From: Patz, Logan W.
To: ["Kent Beierle"](#)
Cc: [Ortiz, Monica](#); [Al-Najjar, Marwa G.](#)
Subject: The Cage, 4100 Central SE, K17D114
Date: Friday, August 11, 2017 2:10:00 PM
Importance: High

This plan was going through for building permit and a concern was brought to our attention. The walls on the parking structure appear to be solid and will obstruct the drivers view from potential pedestrians.

17005
AS001

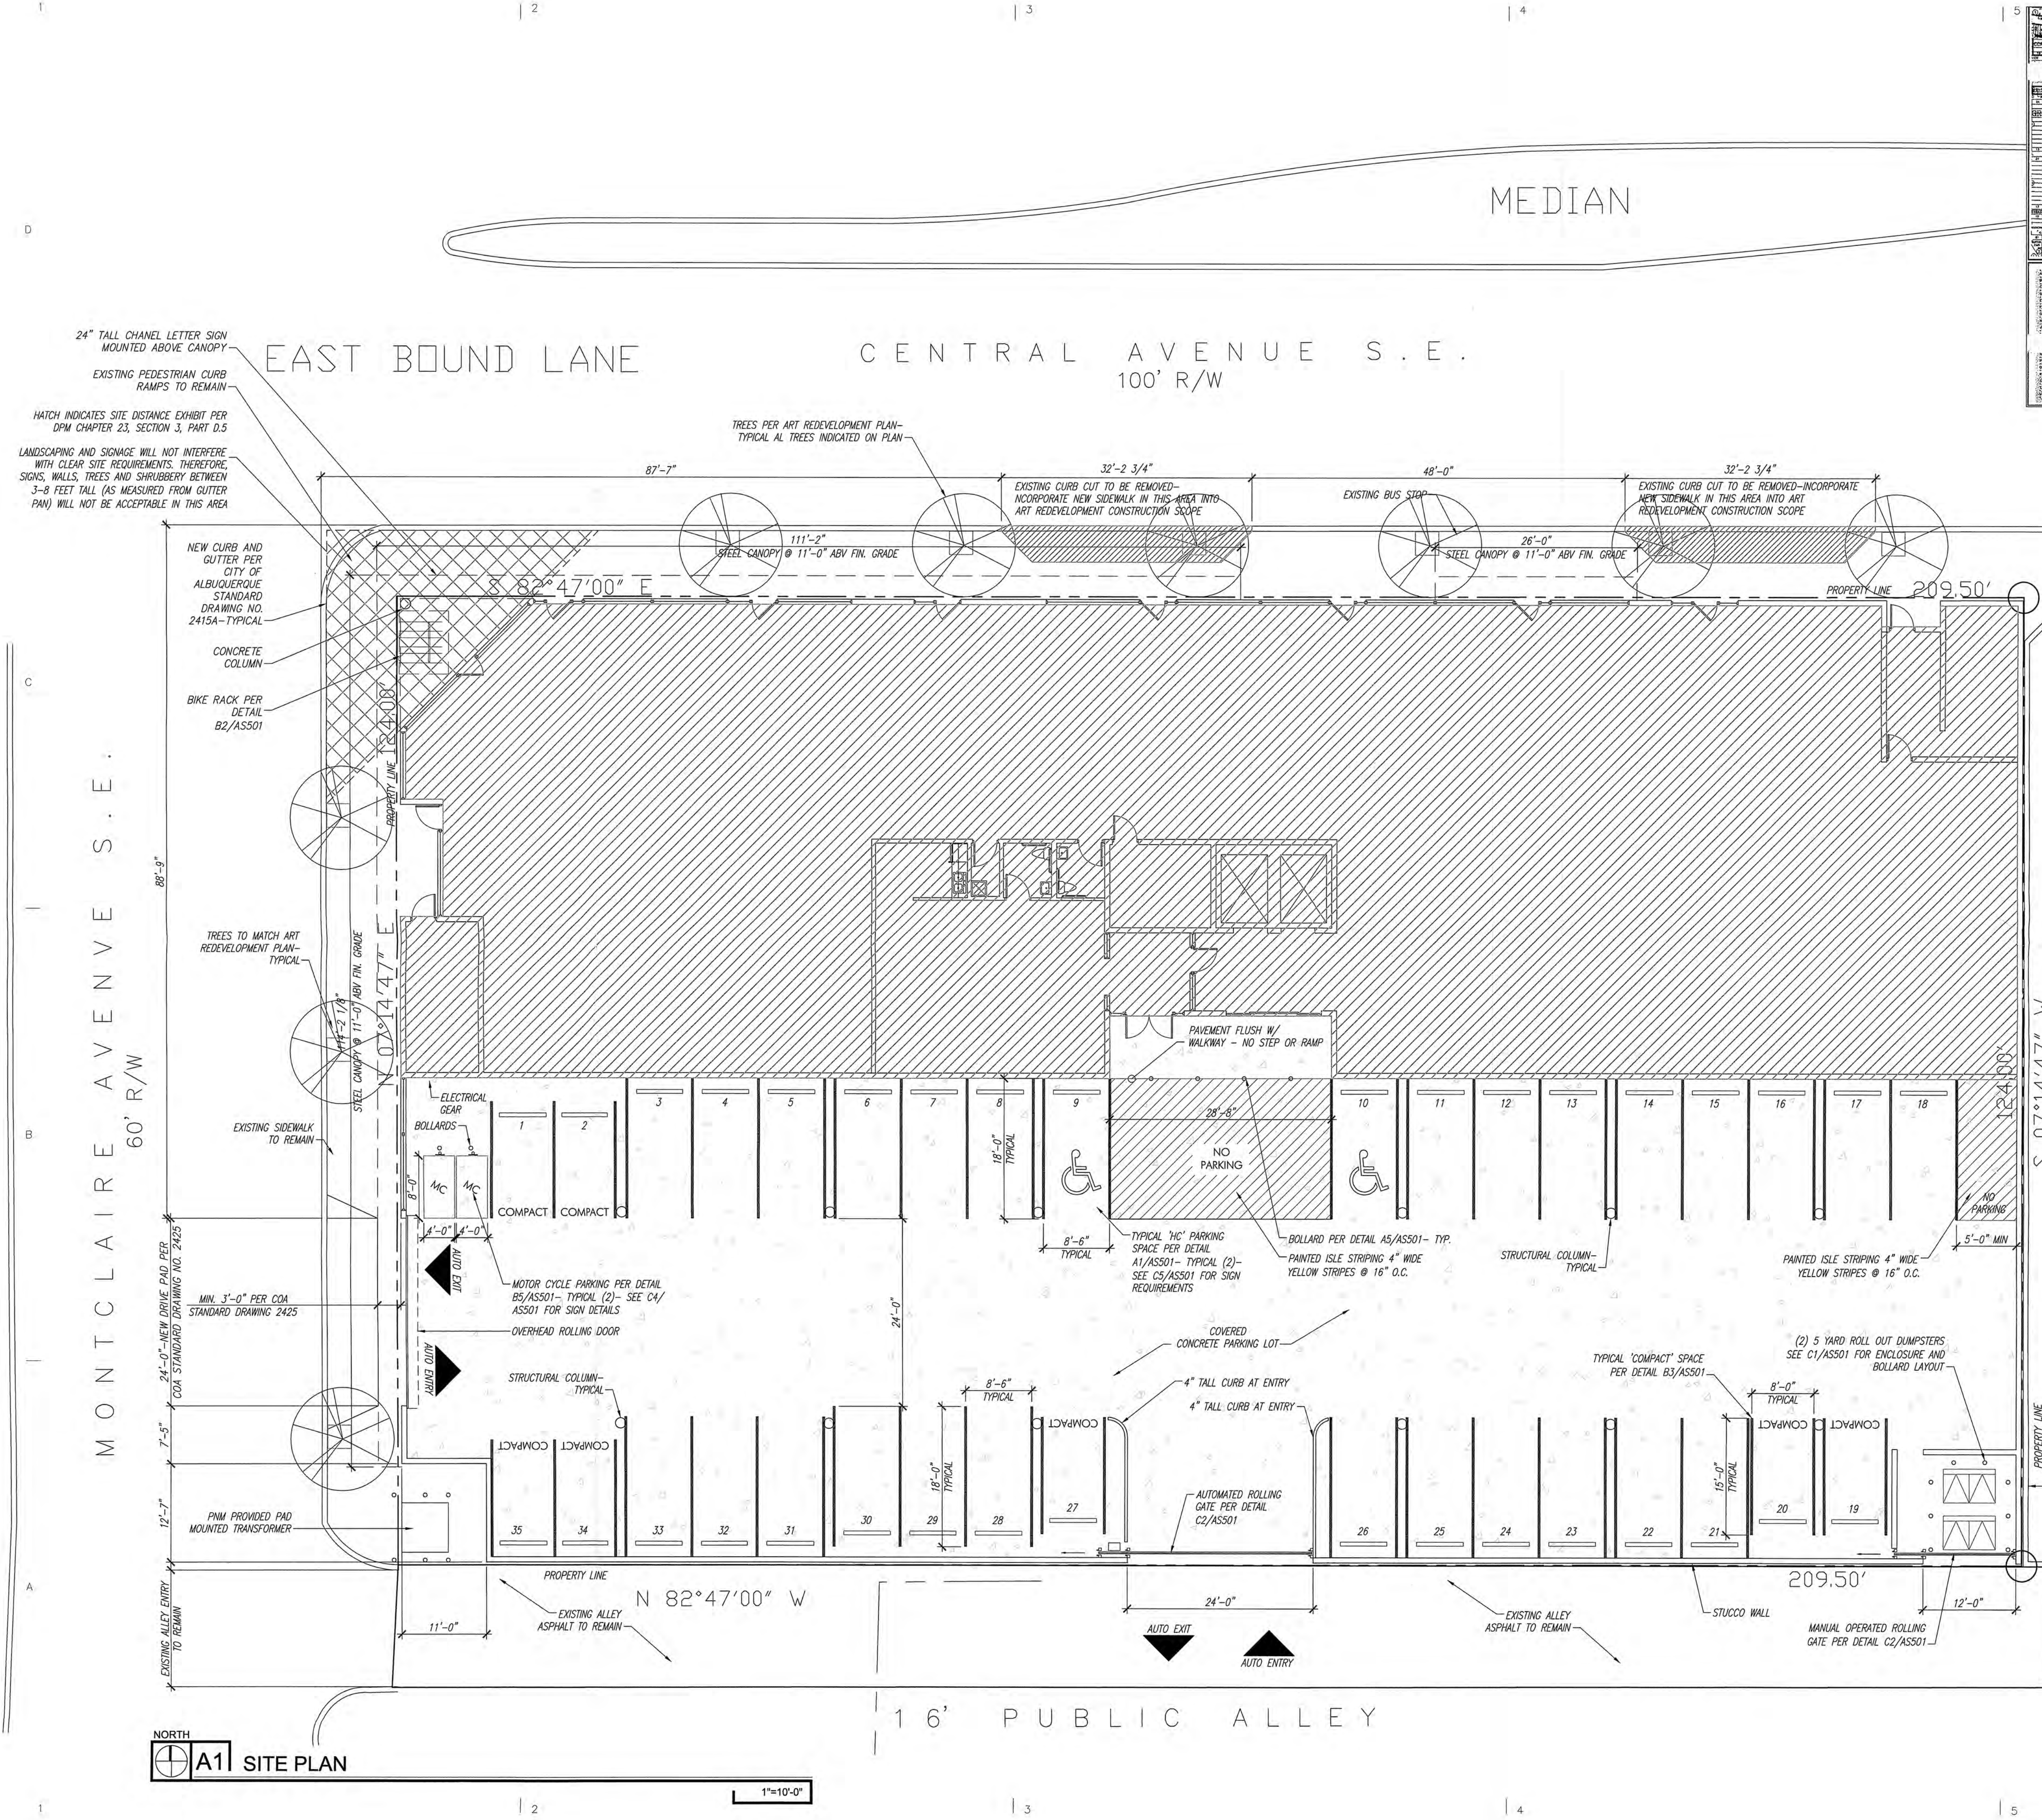
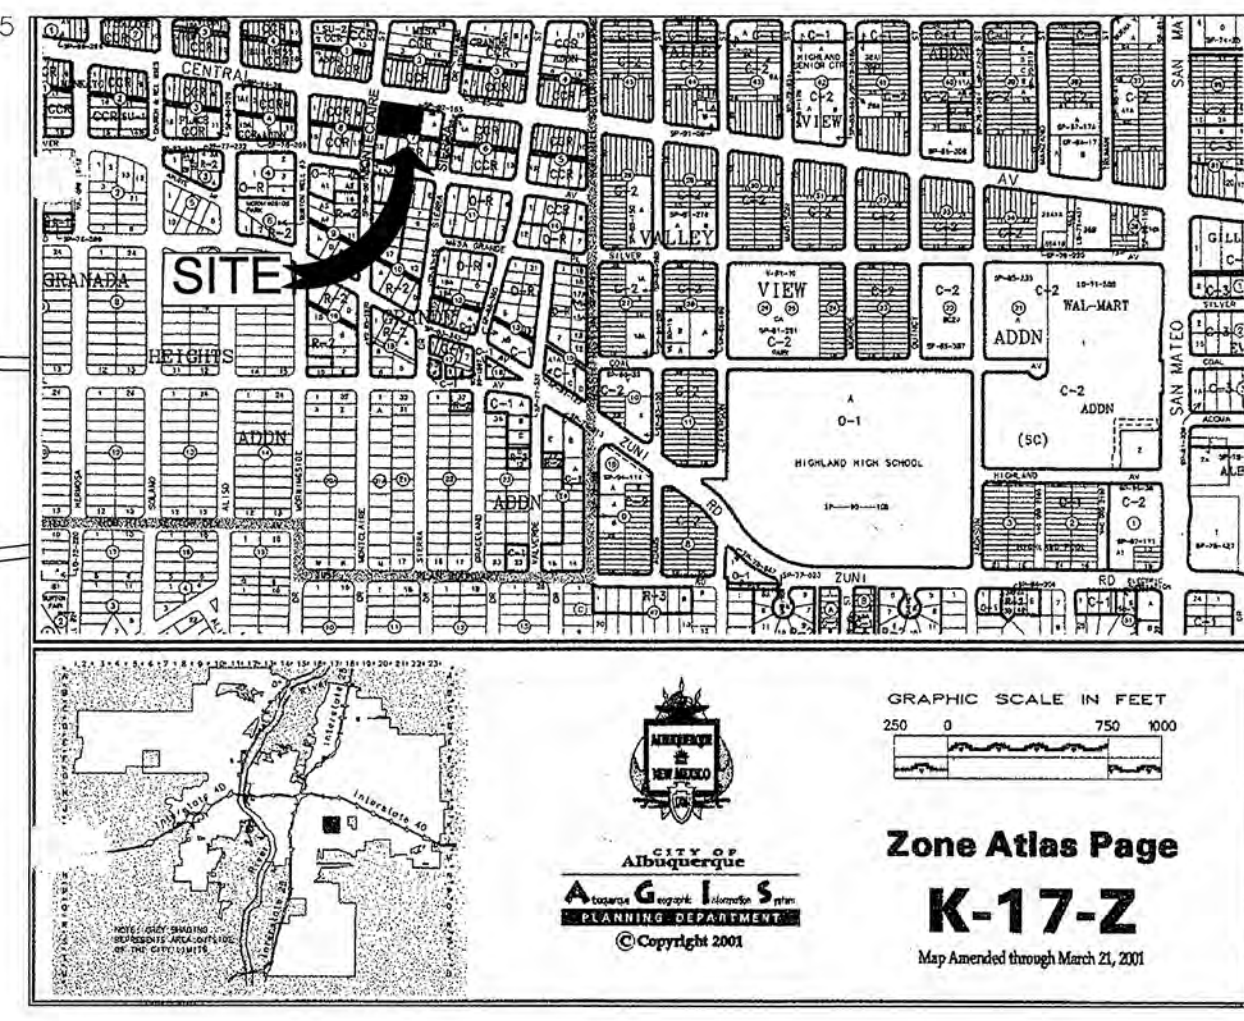
We would like to add two conditions for approval of final inspection. The conditions would be to add convex mirrors at the point of egress and signage stating "Slow watch for pedestrians".
